Subject: FW: BR/302/18/PL : 71 Hawthorn Road

Just following up on how your progressing with the revised parking plan to mitigate the concerns of highways?

Many thanks for your call last week. As discussed please find attached amended drawings following your advice. Please note, revised parking layout, amenity provision, inclusion of bin and bike stores and

SITE PLAN (Proposed) @1:200

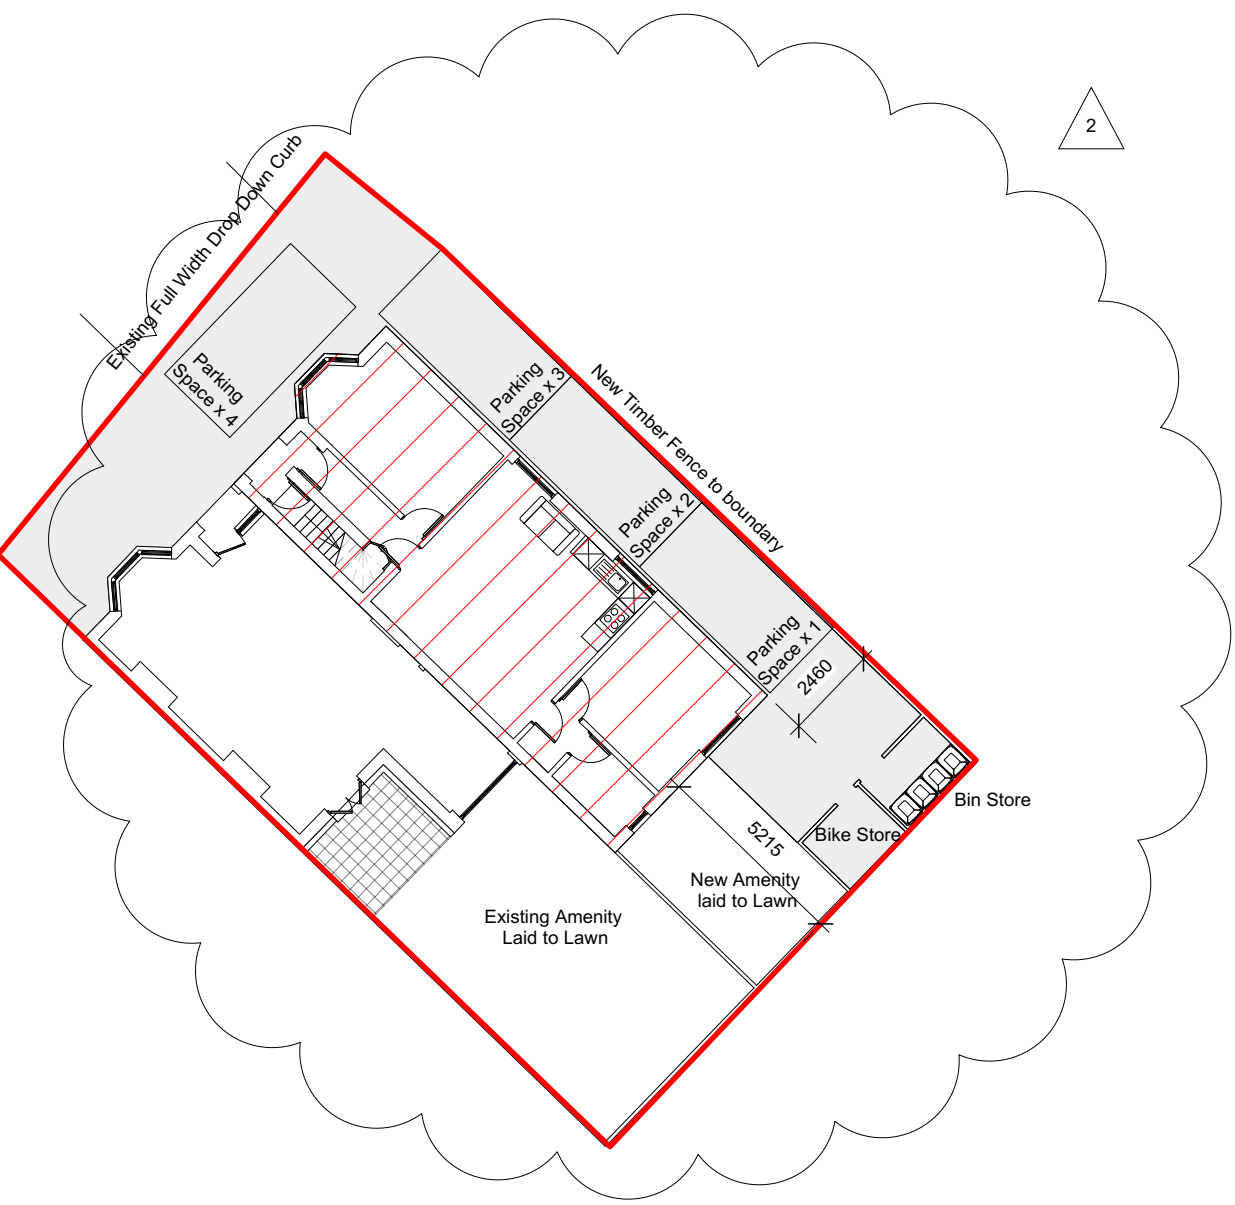
Without a revised scheme the authority will need to review the parking requirement for the total number of units as proposed.
